February 28, 2020

Timberland

9027 SE 60<sup>th</sup>. ST.

2001-170

PLAN, ALL ROOMS TO BE FINISHED BY THE CONTRACTOR. SEE SPECIFICATIONS FOR FINISHES. SEE ELECTRICAL AND MECHANICAL SCHEDULES FOR EQUIPMENT SIZES AND LOCATIONS. SEE NOTES FOR DIMENSIONS AND FINISHES. SEE NOTES FOR INTERCONNECTIONS OF ELECTRICAL AND MECHANICAL SYSTEMS.

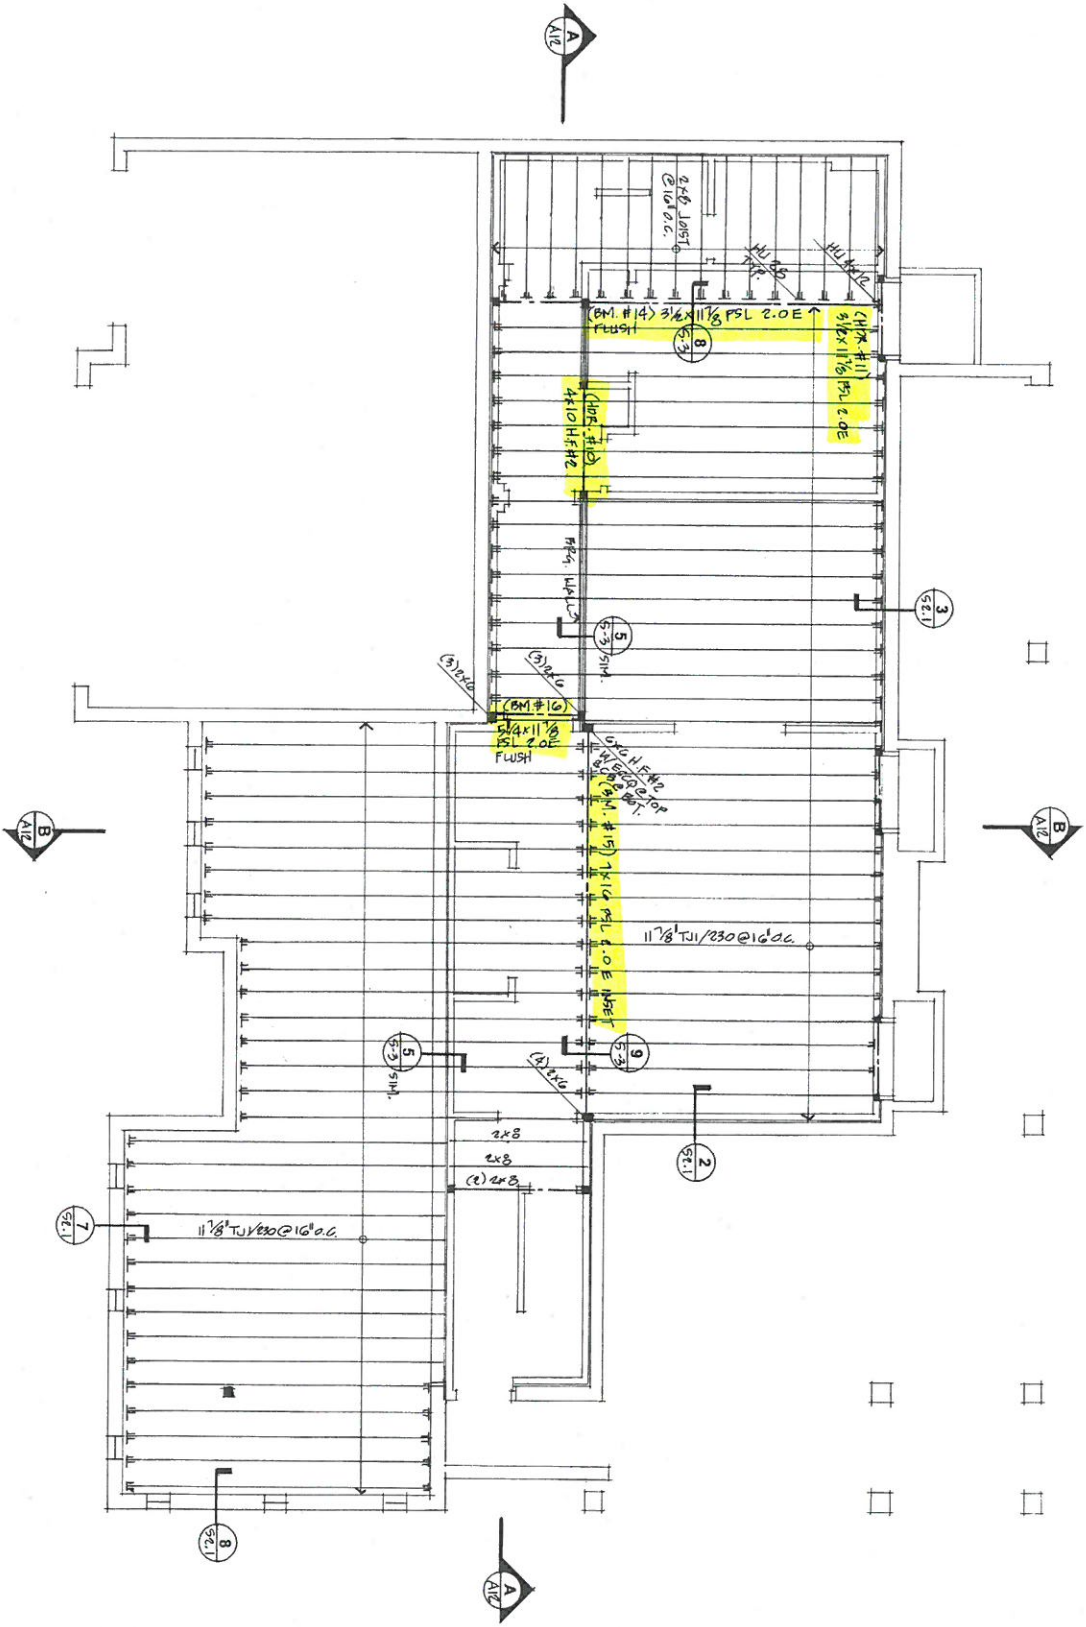
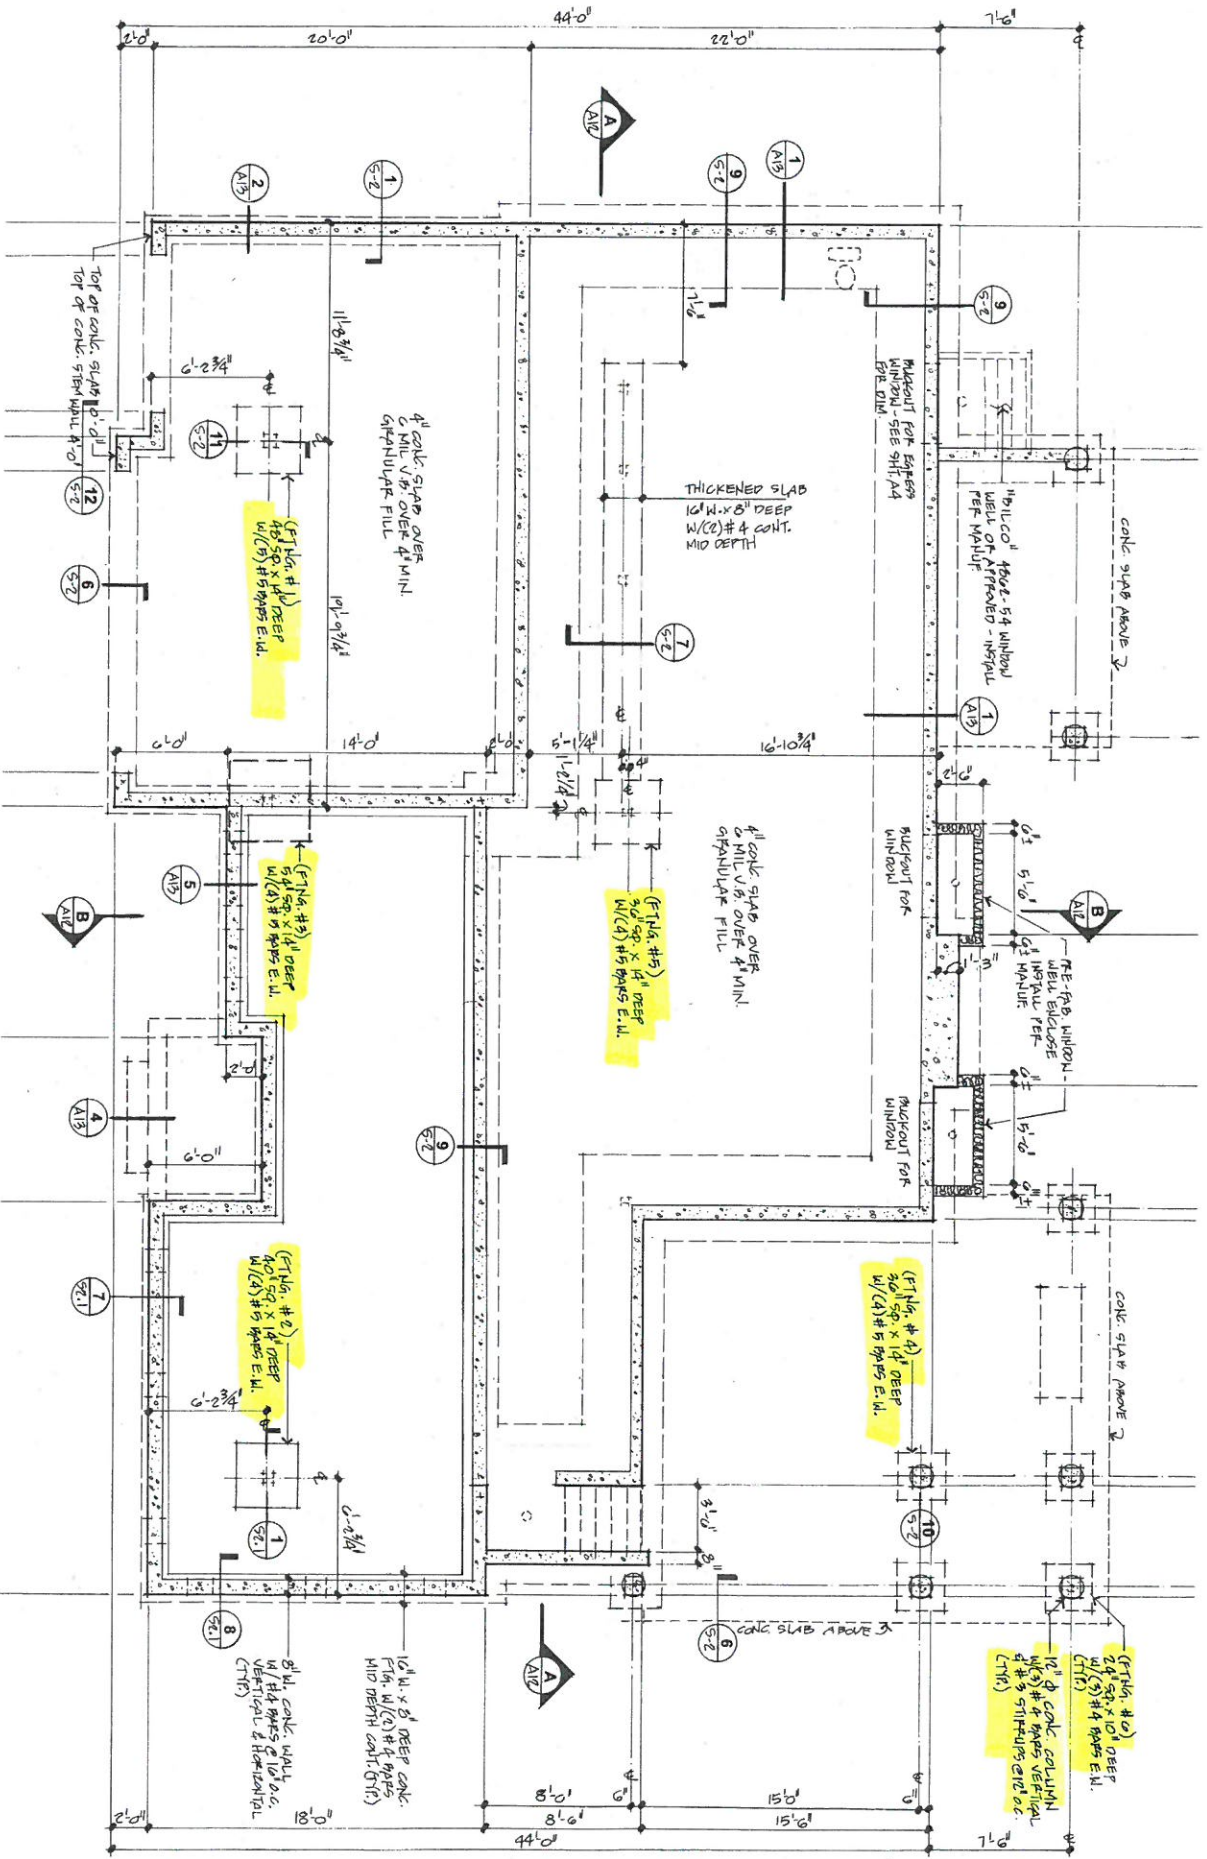
Key plans are already provided on structural calculation sheets page 5-10, attached separate as well.

**SITE PLAN**

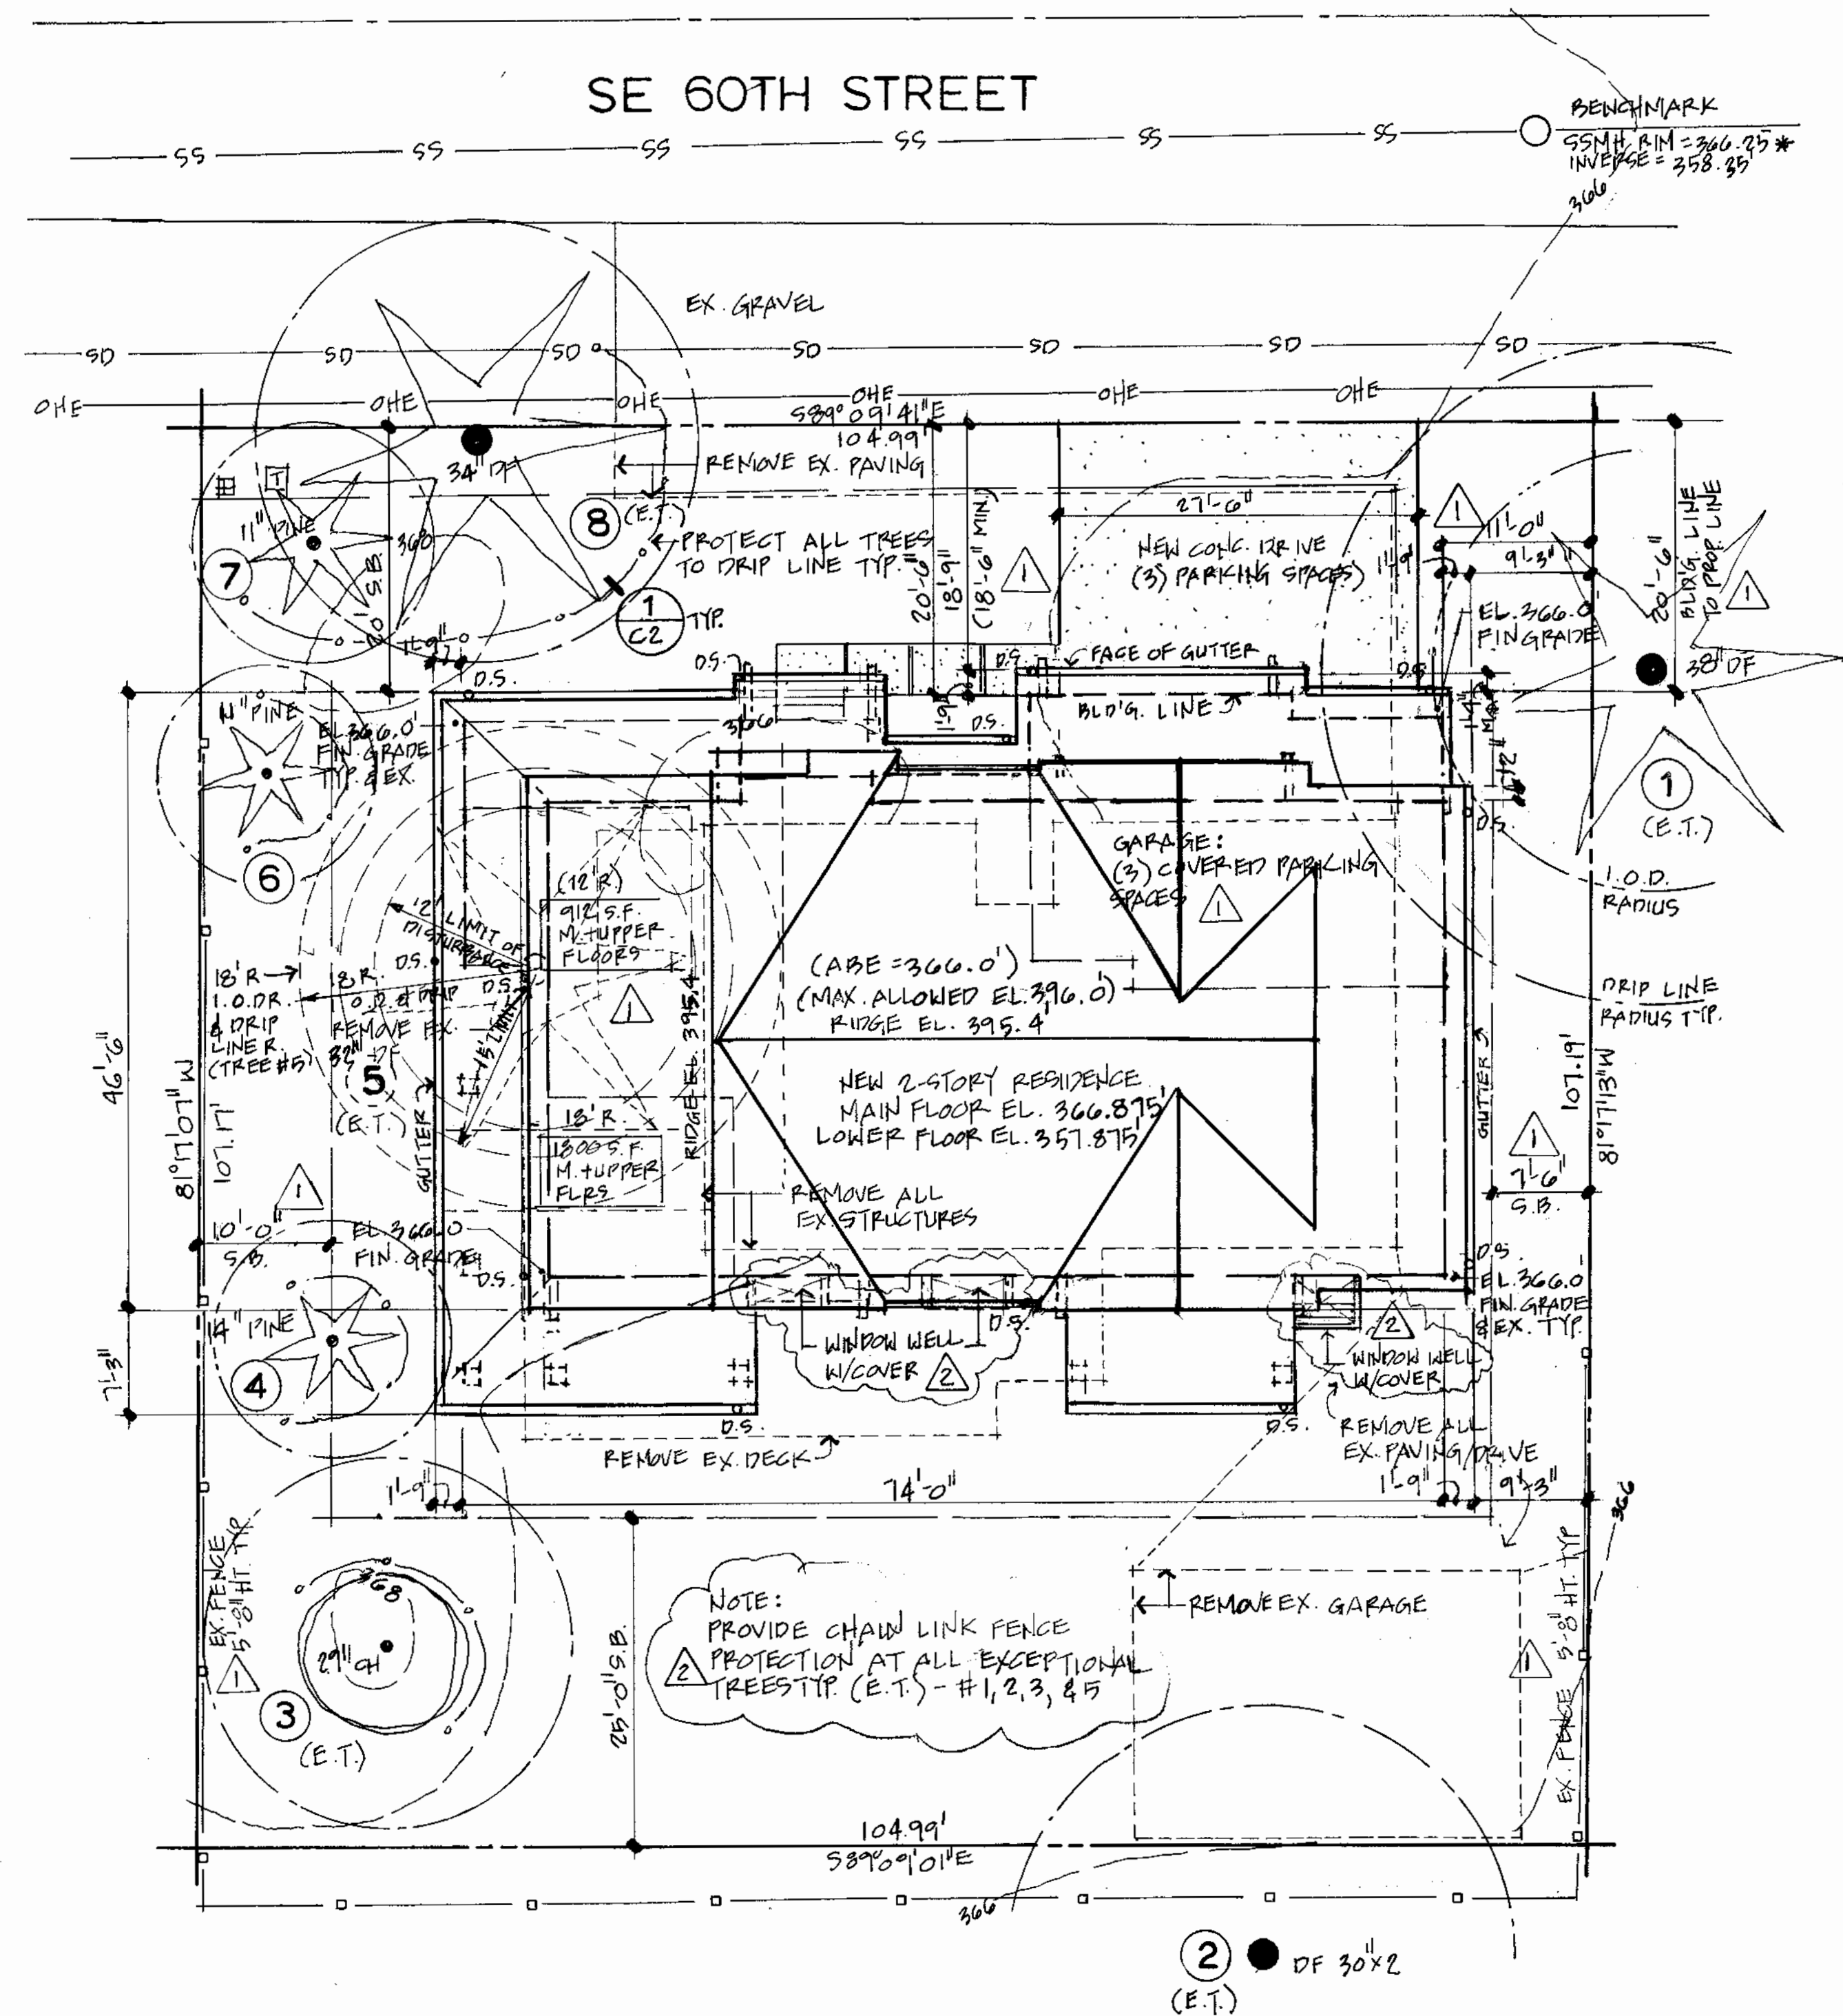
Added Lot size and slope to sheet A1.

Added Building pad to sheet A1.

Added parking spaces covered and uncovered note sheet A1.

Added applicant information sheet A1.

Driveway width and length is already indicated, added additional dimensions sheet A1.

There are no walls or rockeries proposed, fall protection not required (covered window wells), added height of existing fence sheet A1.

Added lot coverage, hardscape & GFA calculations sheet A1.

Revised side yards setbacks sheet A1.

Provide slope calculations sheet A1

Added additional dimensions indicating no intrusions into side yard setbacks.
